Application no: H02-0496-11

Location: Martins Farm
Postland
Crowland
Peterborough
PE6 0JU
PE6 0JU

Amendment: Amended design details (dwg. nos. 300-07-16, -02B, -03A, -04B, -05B, -08A, -09B, -12B, -15A)

Re: Martin's Farm, Postland, Crowland – Your Ref: H02-0496-11 – Conversion of barns into two residential dwellings

Drawing Title:
External Door Details

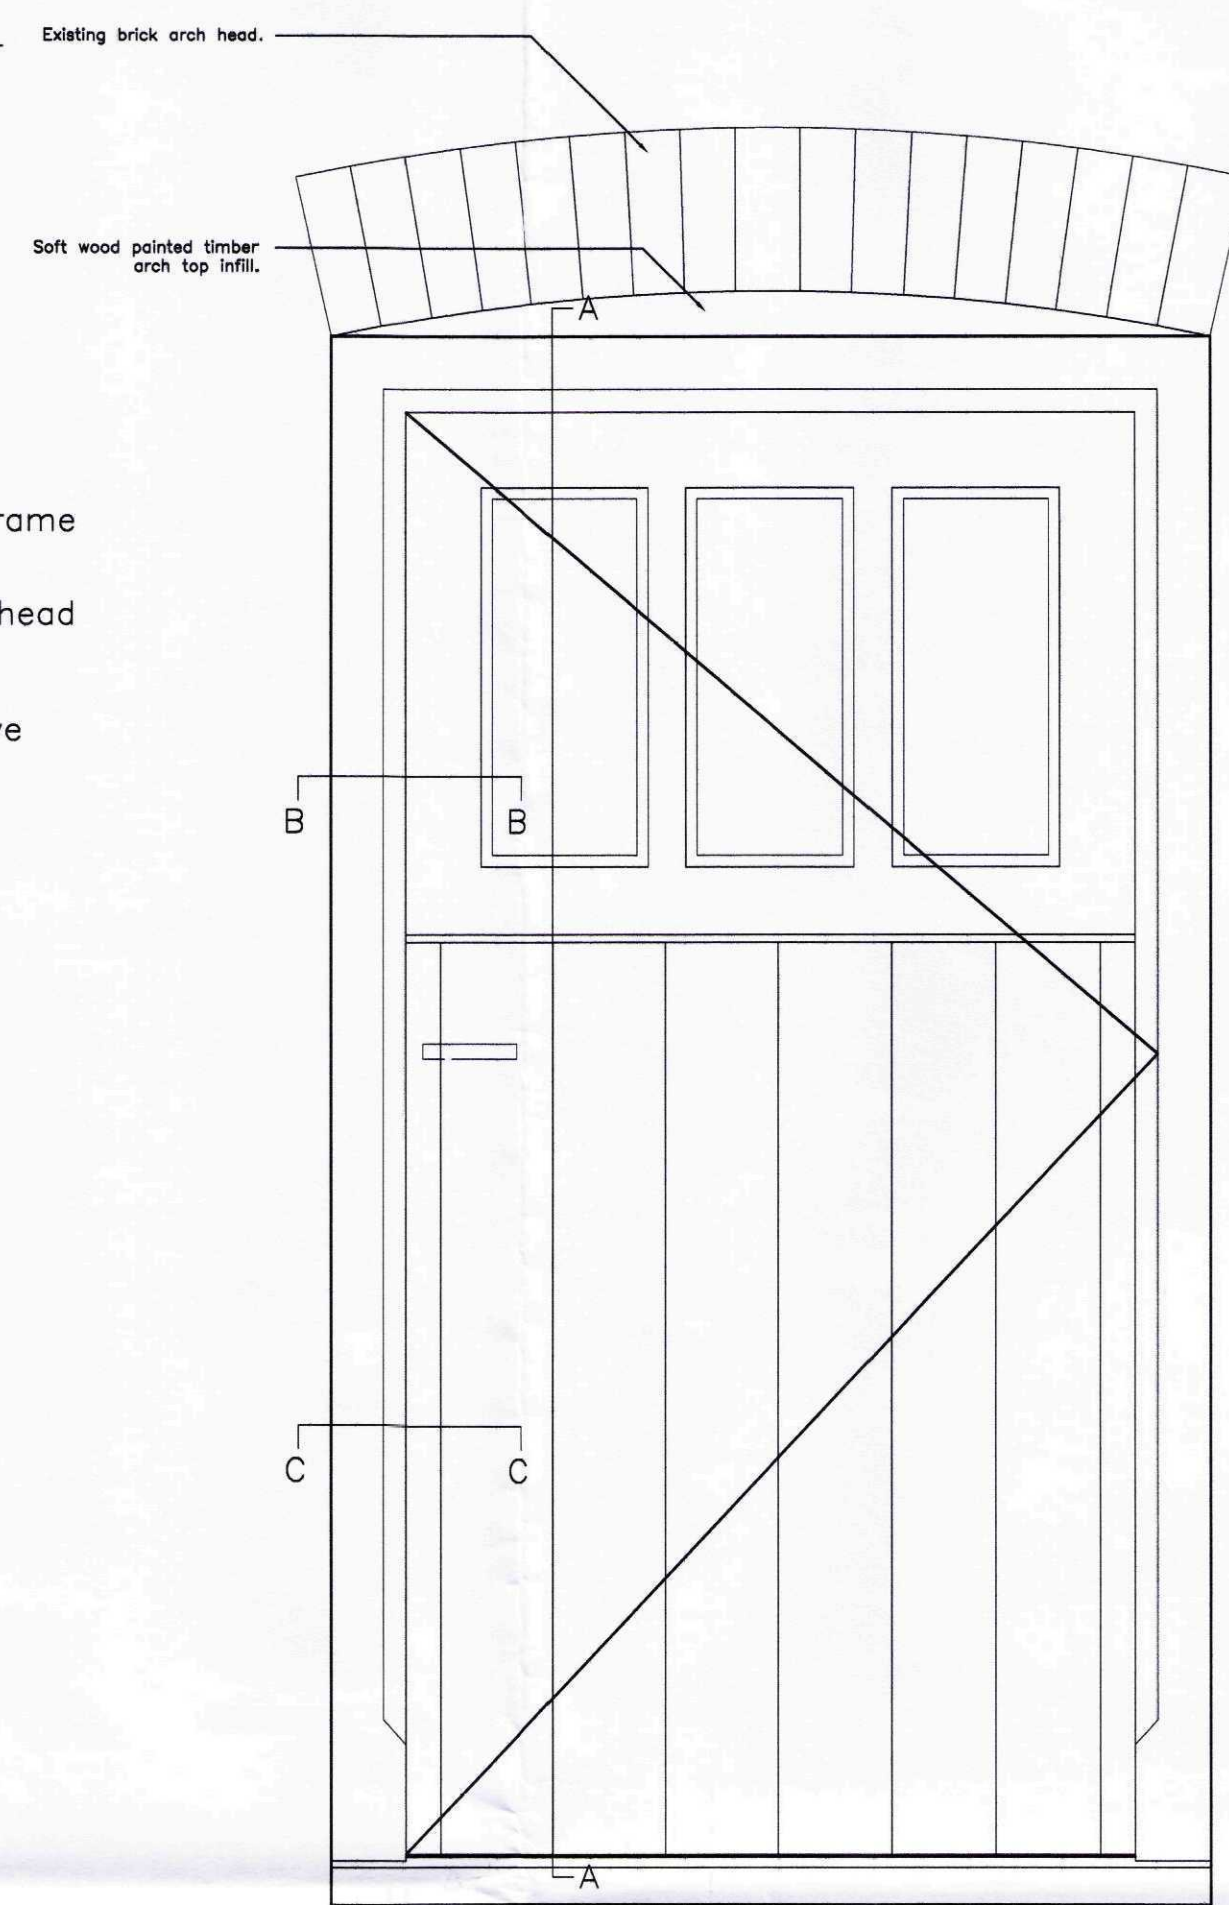
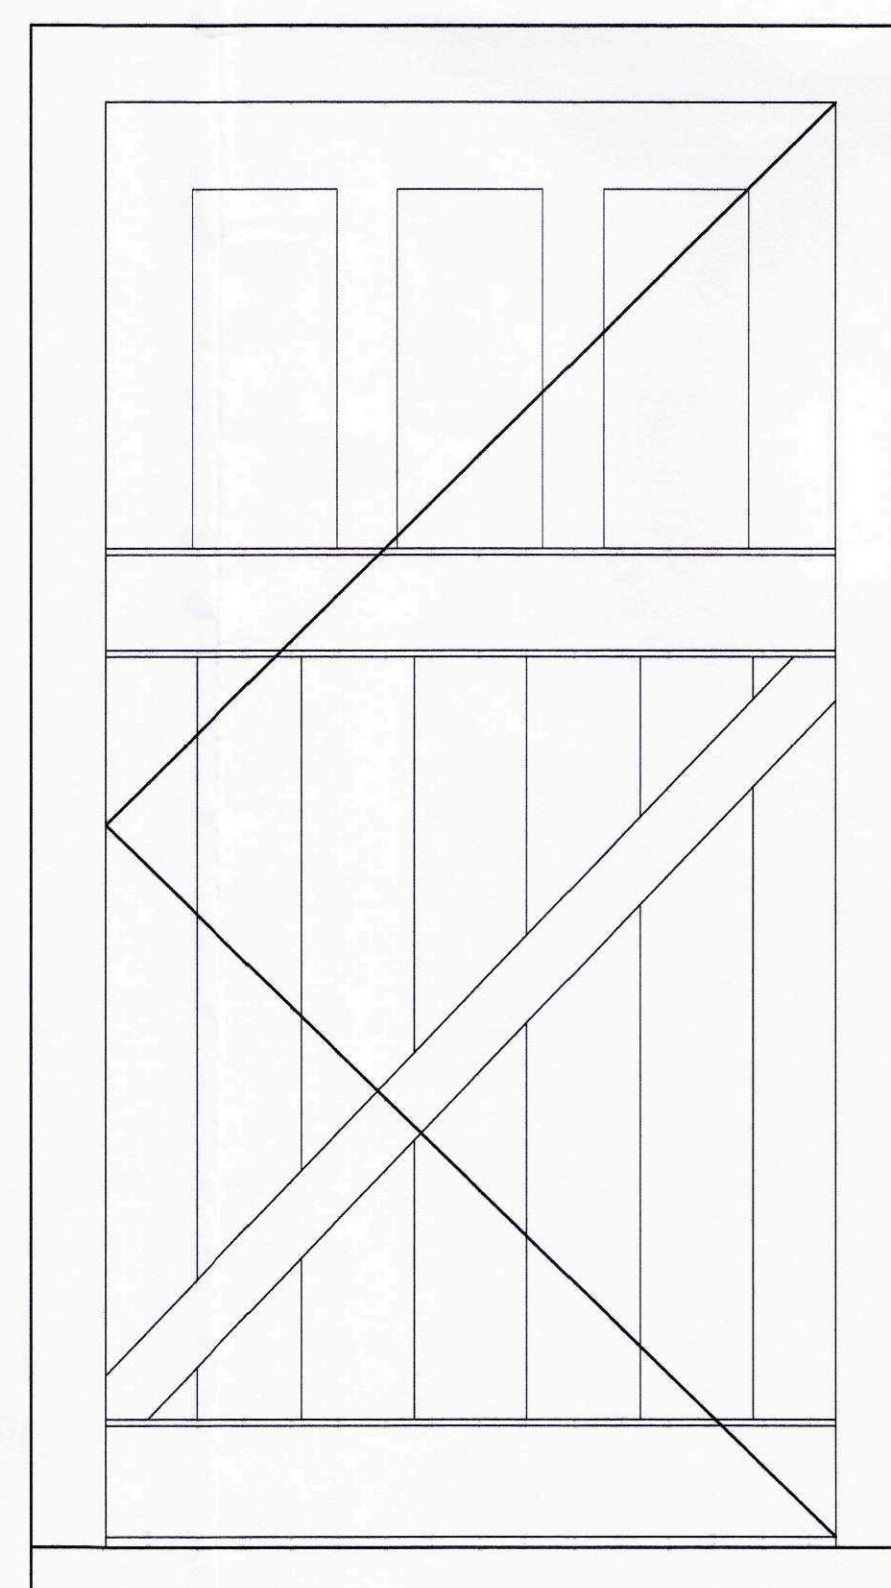
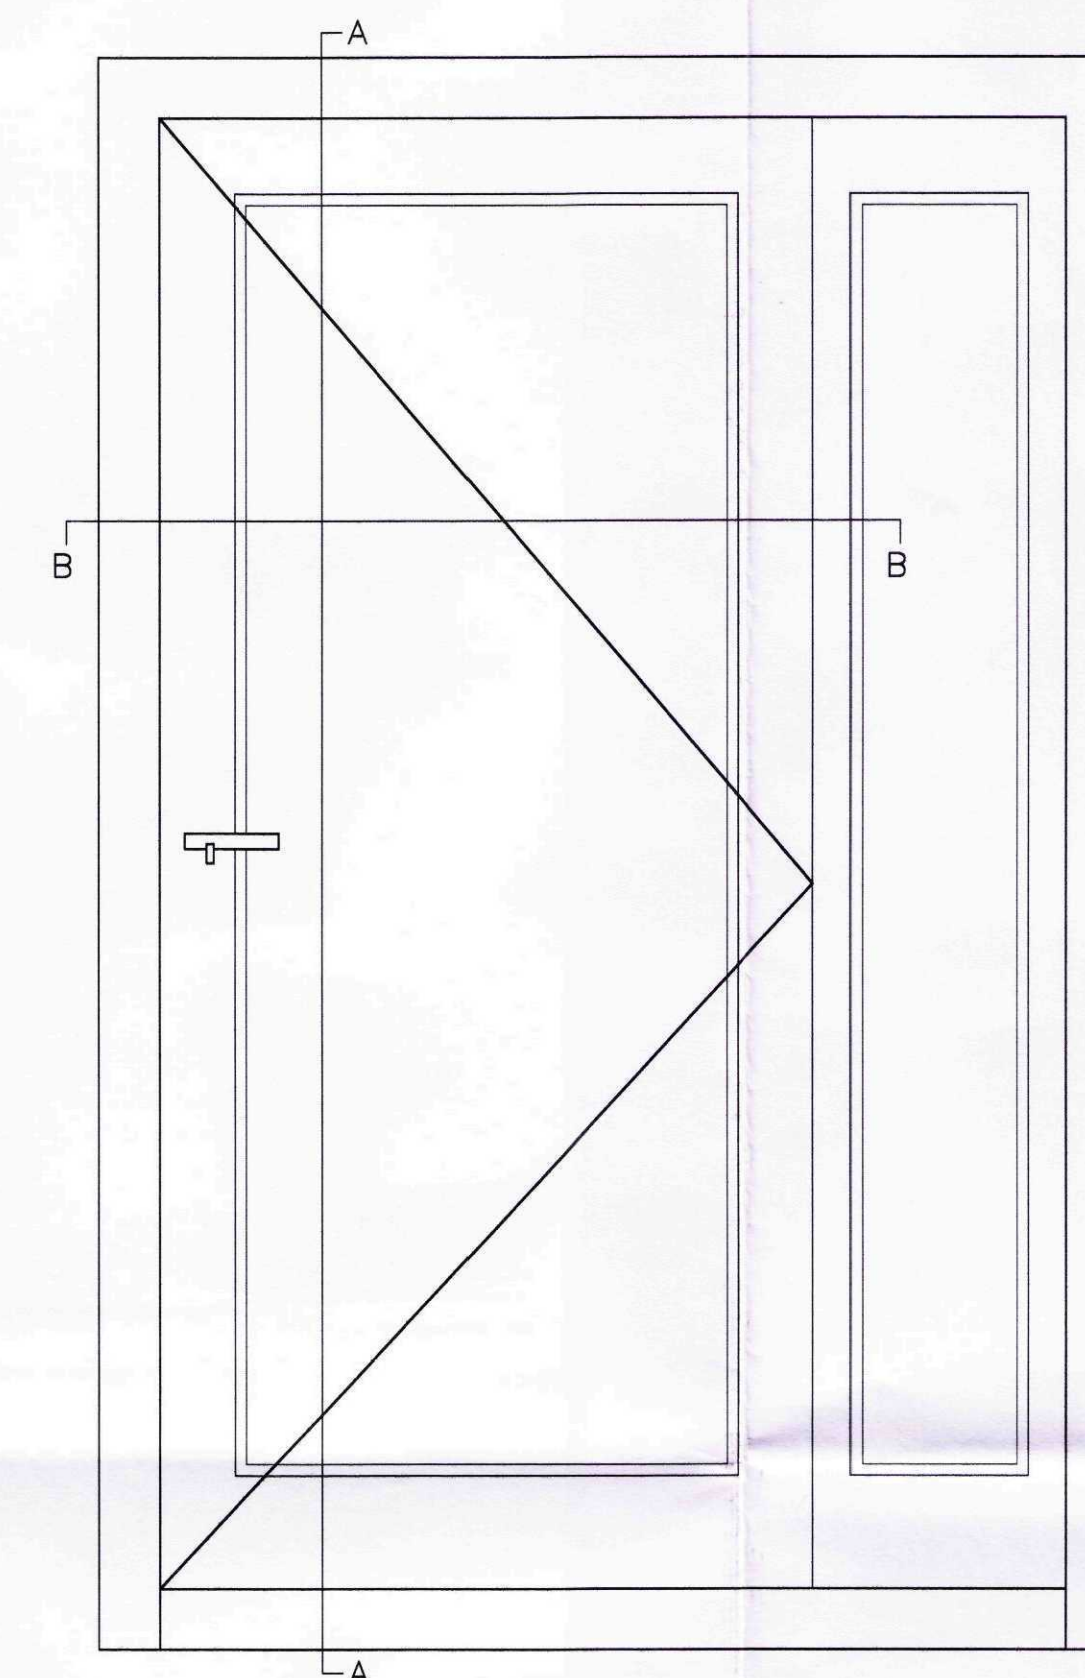
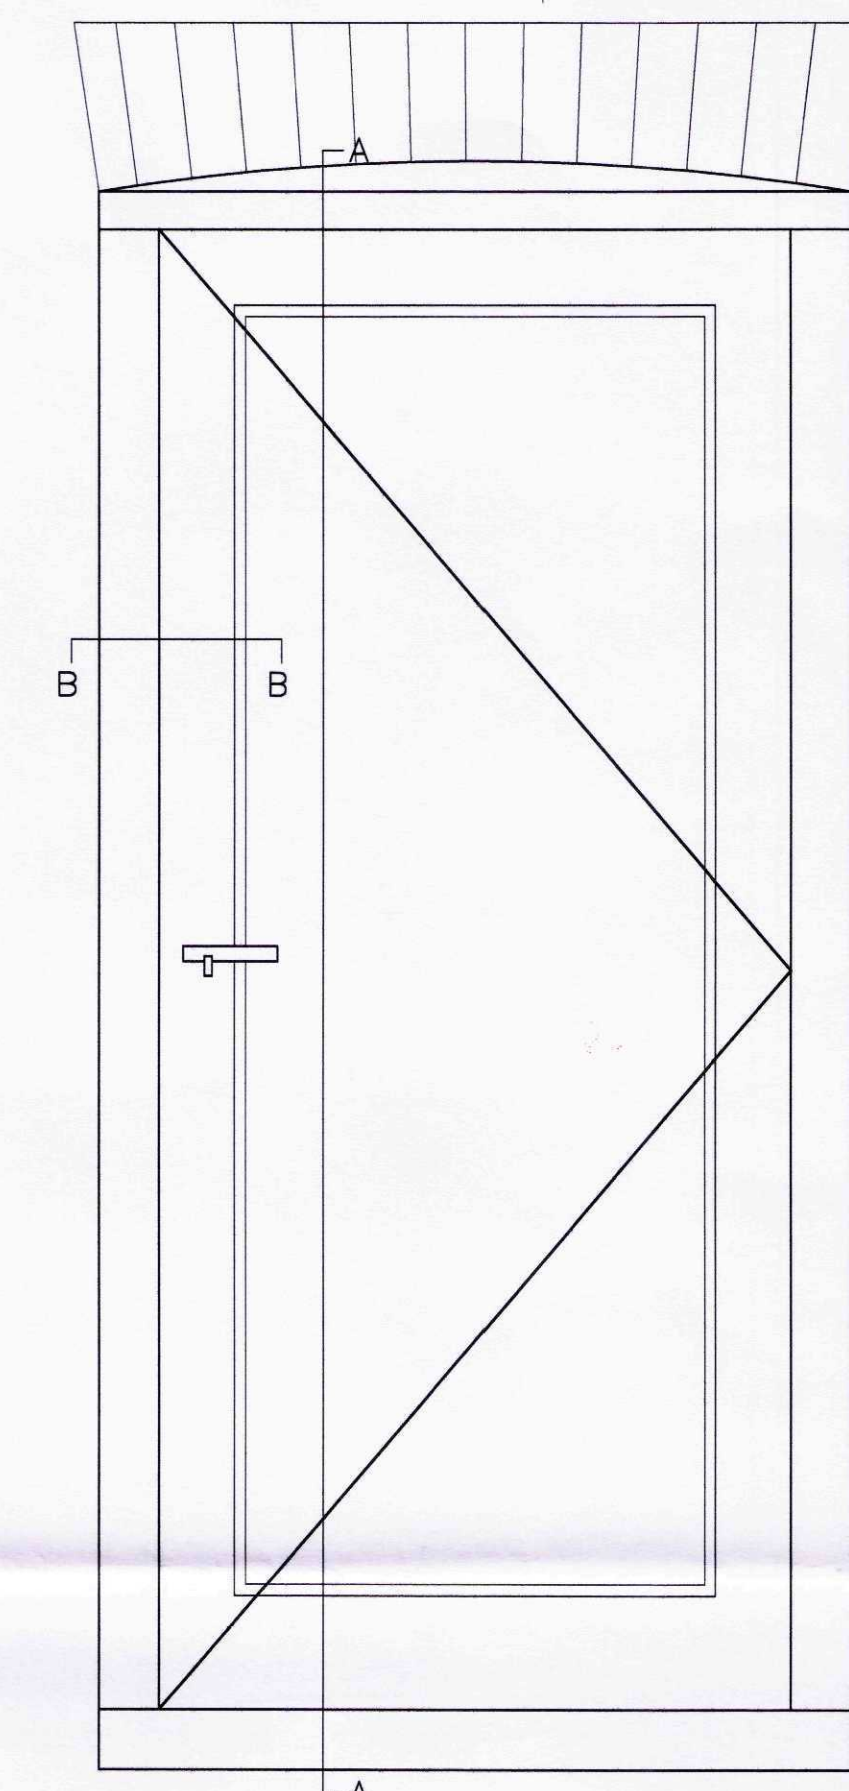
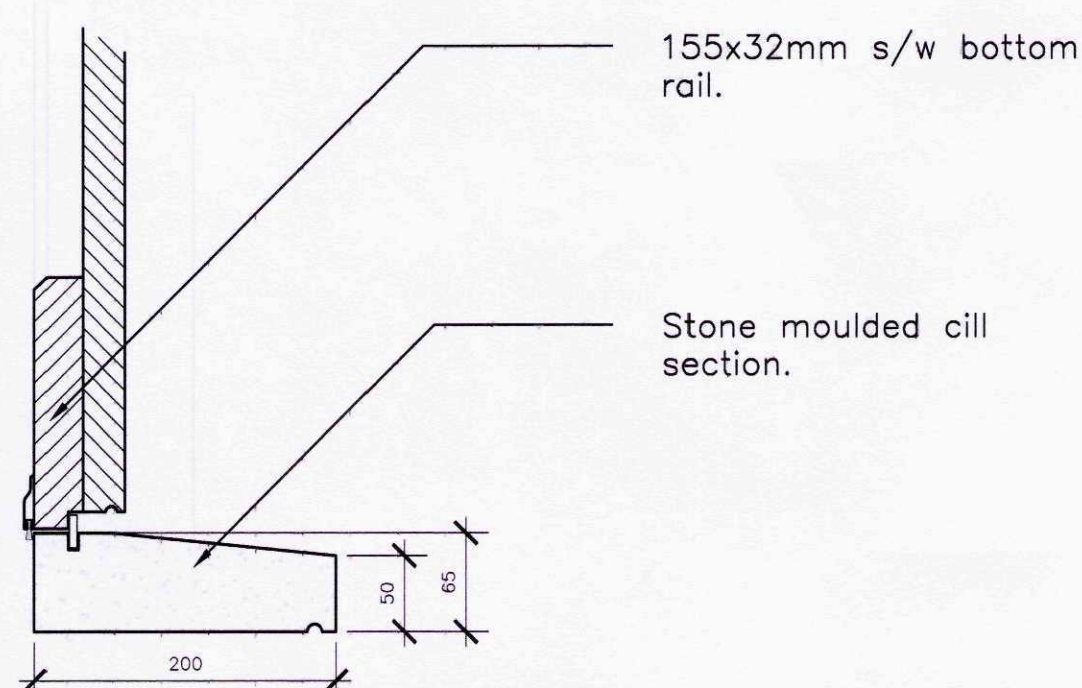
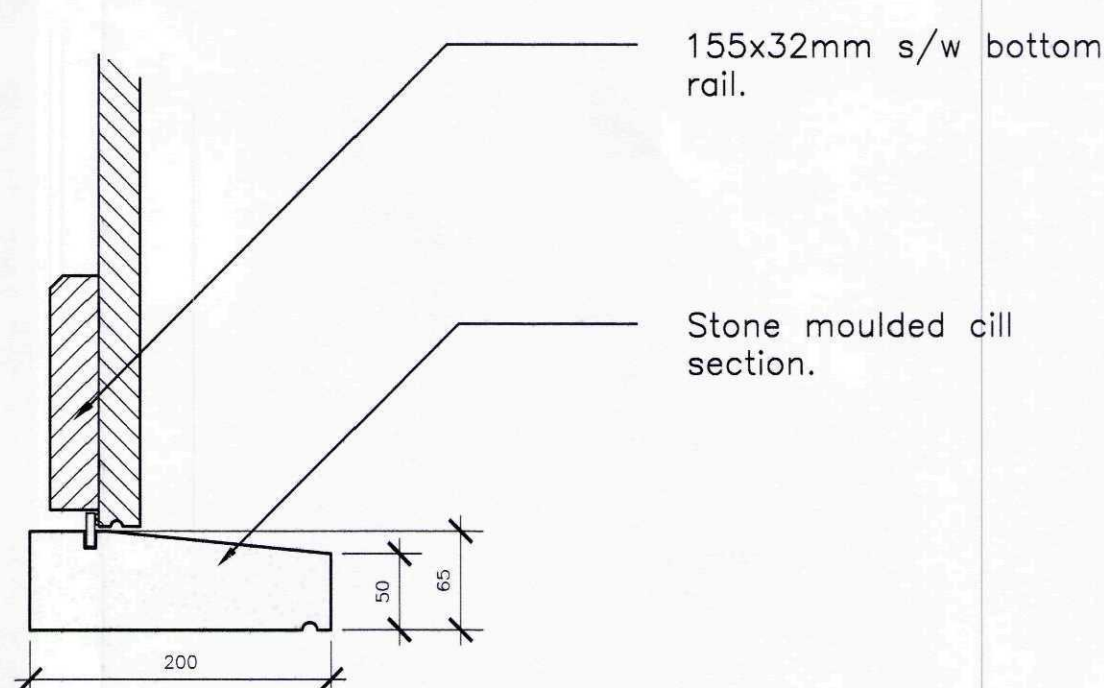
With regard to the door details please refer to the enclosed revised details.
